The Planning Inspectorate

The Planning Act 2008 and The Infrastructure Planning (Examination Procedure) Rules 2010 – Rule 17

Application by Cory Riverside Energy for an Order Granting Development Consent for the Riverside Energy Park

Changes to the Application

SHEET 2 OF 16

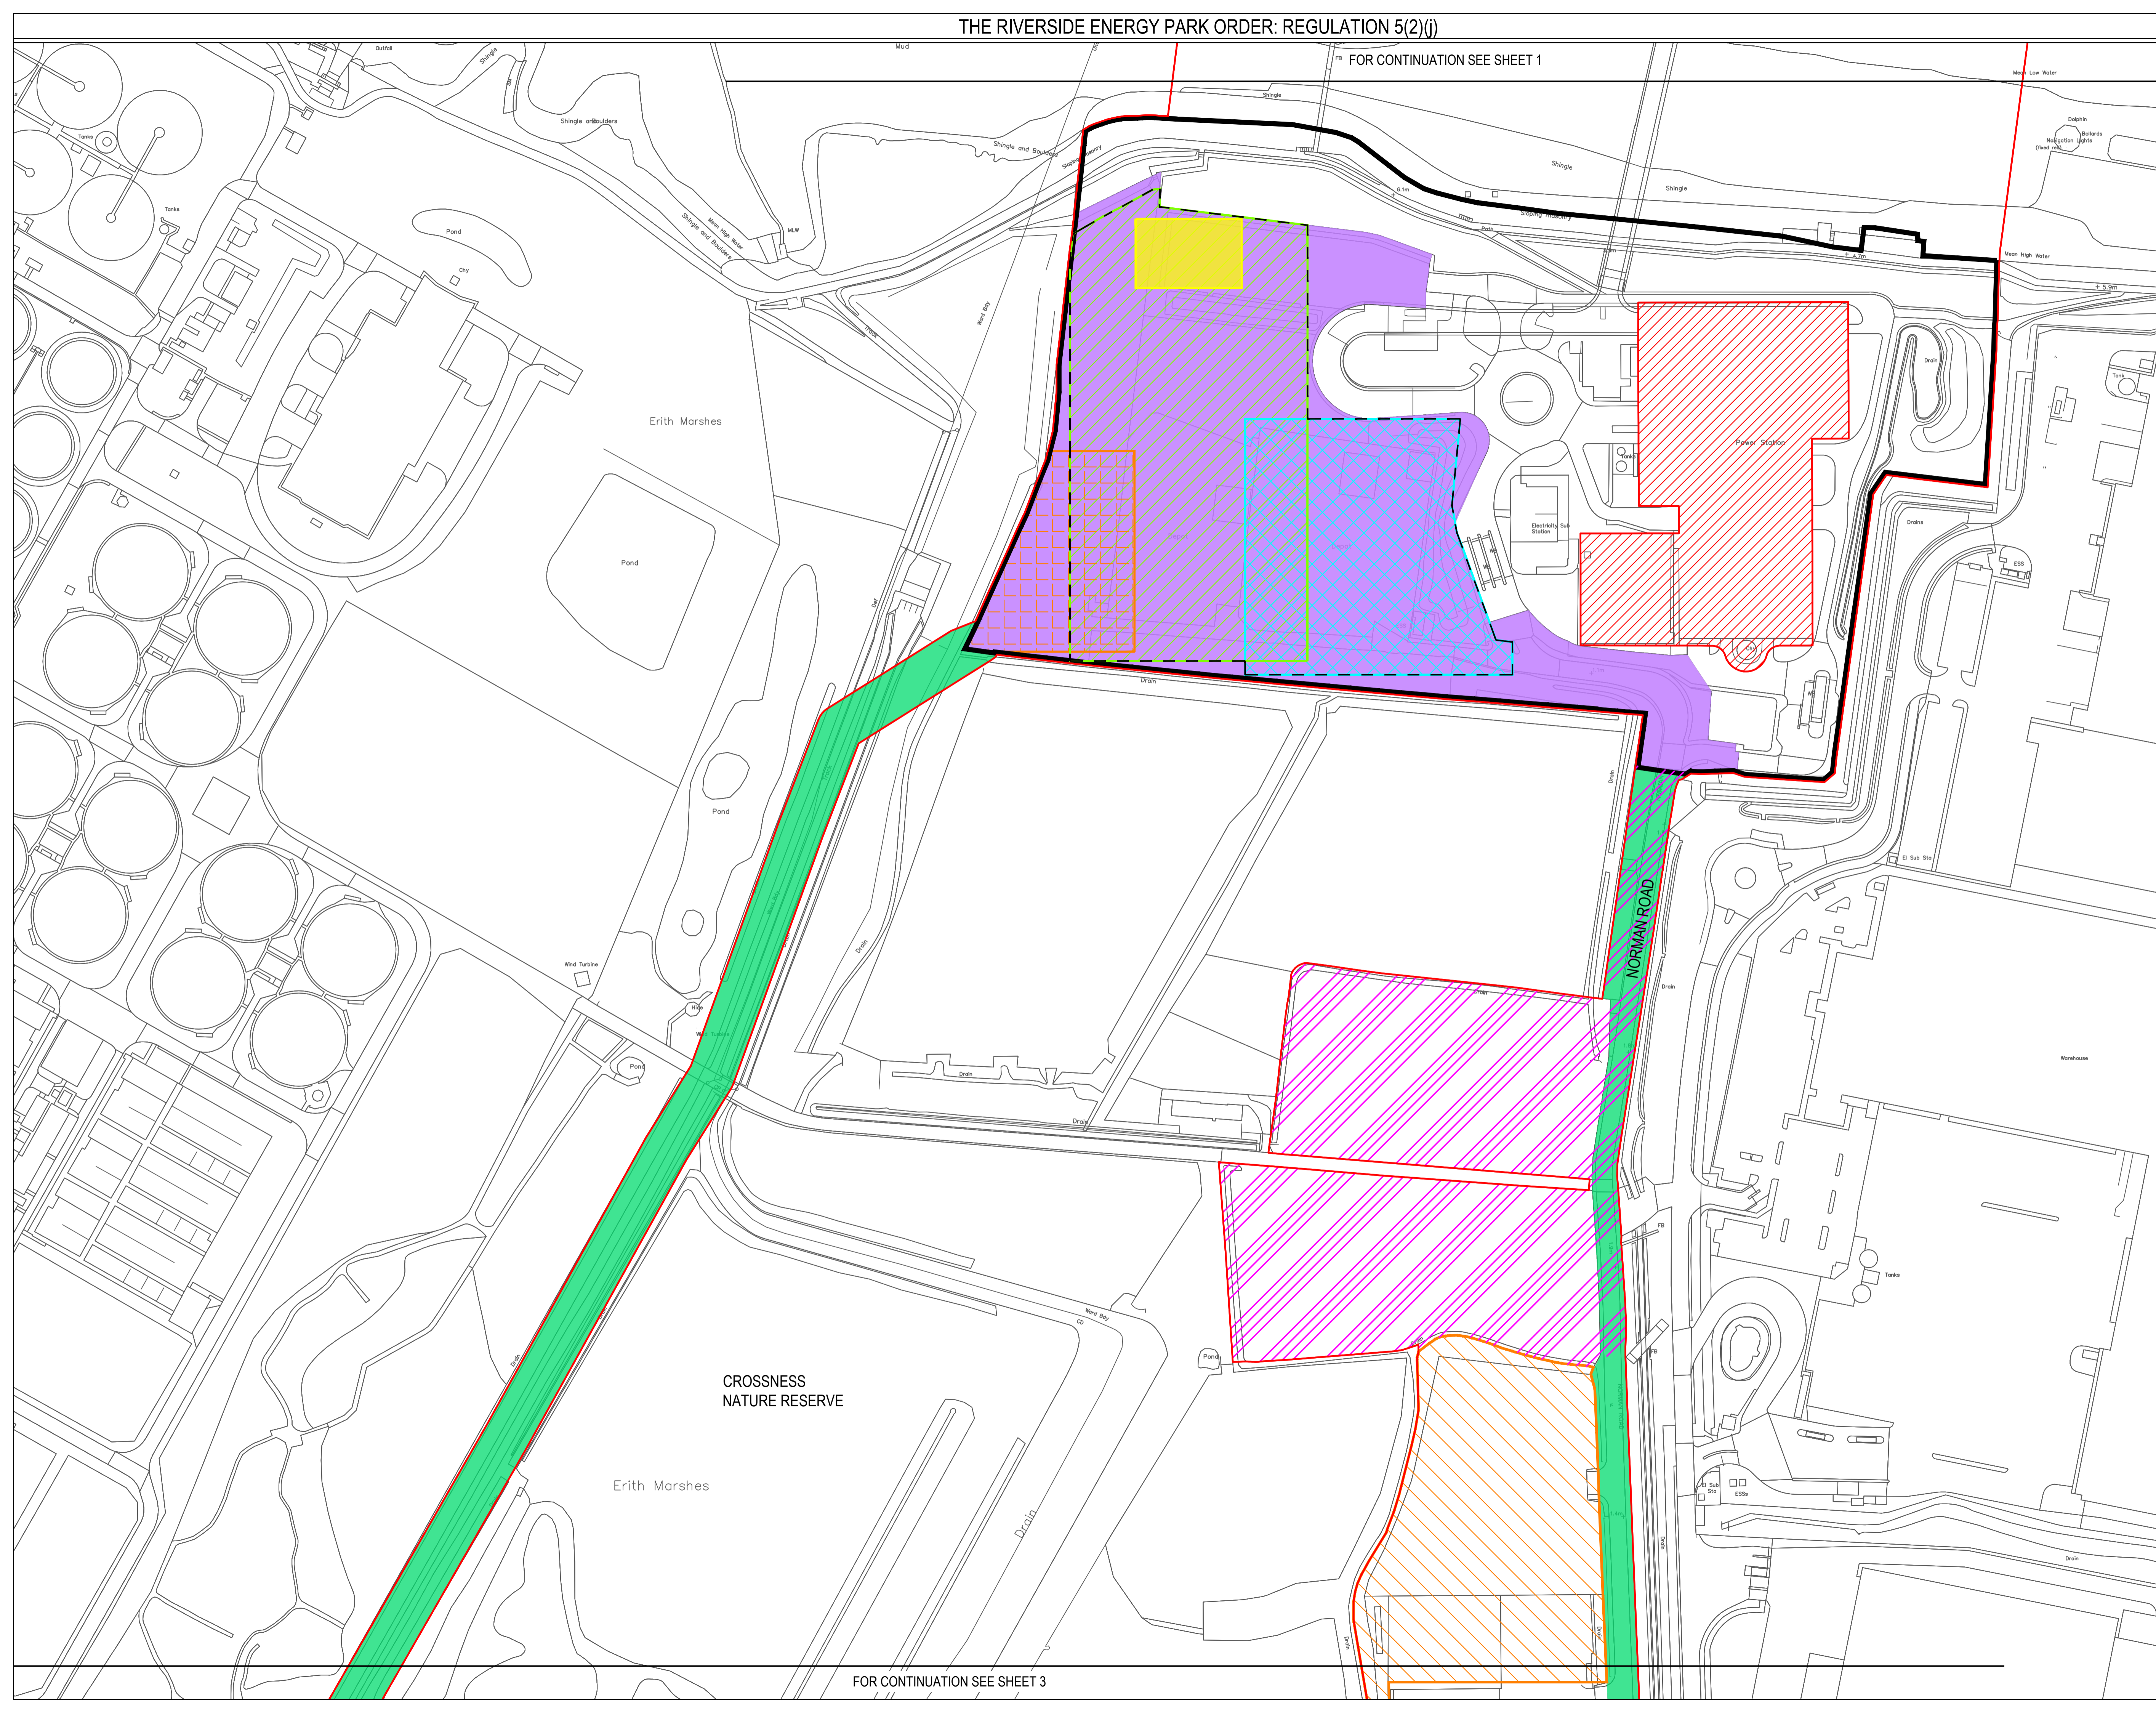
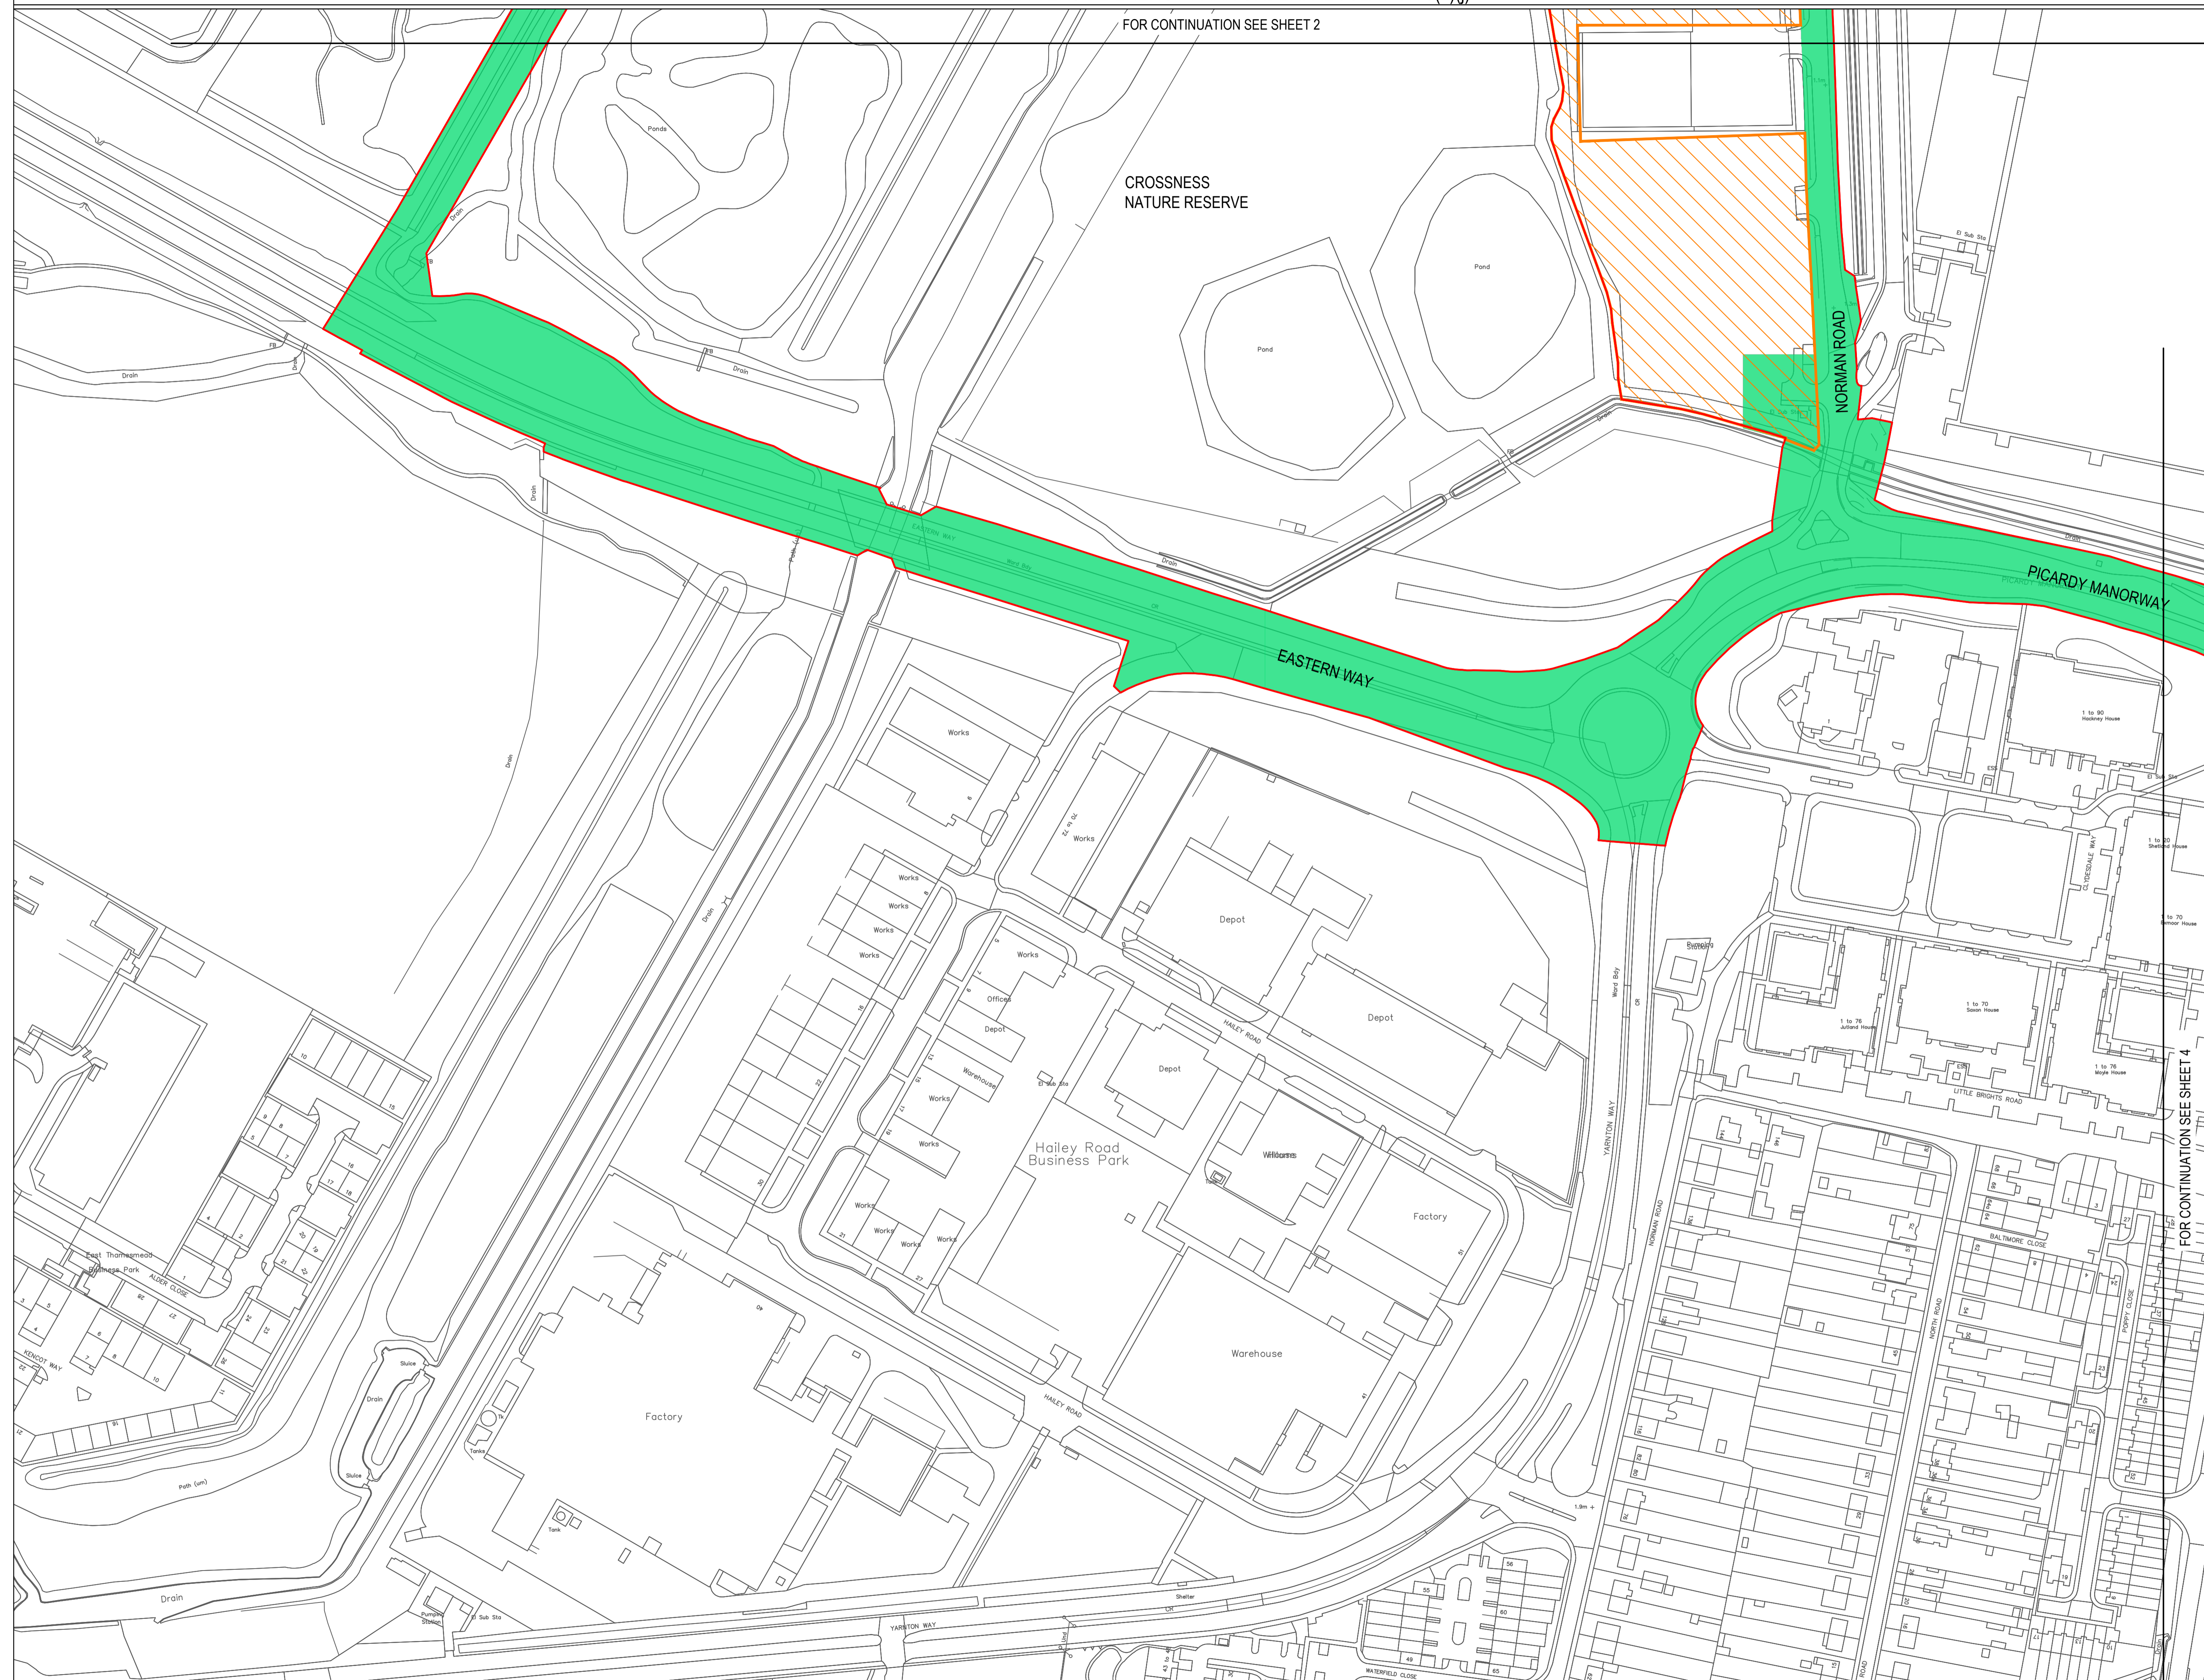
a) The removal of plots 02/53 and 02/55 from the Main Temporary Possession Construction Compound and the use of plots 02/43, 02/44, 02/48 and 02/49, (the Data Centre site) as part of the Main Temporary Possession Construction Compound.

These would be used for Work No. 8 - Works to construct temporary construction compound including—hard standing; vehicle parking; accommodation block(s); new or alteration to accesses; and construction fabrication areas”.

Revised Land and Works Plans were submitted showing these changes. (sheets 2 and 3 of REP2-003 and REP2-004).

I received objections from the Friends of Crossness Nature Reserve (REP4-034) and Thames Water Utilities Limited (TWUL, REP4-039) to the proposed changes in the use of the Data Centre site which argued that there would be prolonged disruption from work at this site over a 3 to 5 year period compared to the 3 years considered in the original application and ES. This would have an adverse effect on wildlife, deter visitors and affect their enjoyment of the Nature Reserve. TWUL was also concerned about the proposed shared access to the Data Centre site.

- 3) set out how access to the Data Centre site would be provided if access is not agreed with TWUL and what implications this would have for the Proposed Development as set out in the Land and Works Plans (REP2-003 and REP2-004) and other related documents;

In my view the changes proposed for the use of the Data Centre site are not such that they result in a different project for which a new application would be required but, in the light of the objections submitted, it is my view that they constitute a material change. Nonetheless, I have decided to accept the application changes into the examination.

In order to assist me in examining these changes during the remaining period of the examination the Applicant is asked:

- 1) to respond to the concerns about the proposed use of the Data Centre site that have been raised by the Friends of Crossness Nature Reserve and by TWUL;

- 2) comment, in the light of the concerns raised by the Friends of Crossness Nature Reserve and TWUL, on whether the proposed use of the Data Centre site during the construction period and the delay in developing the Data Centre would result in direct or cumulative impacts that have not been assessed in the ES and the Environmental Statement Supplementary Report. And, if so, provide supplementary environmental information on these potential impacts;
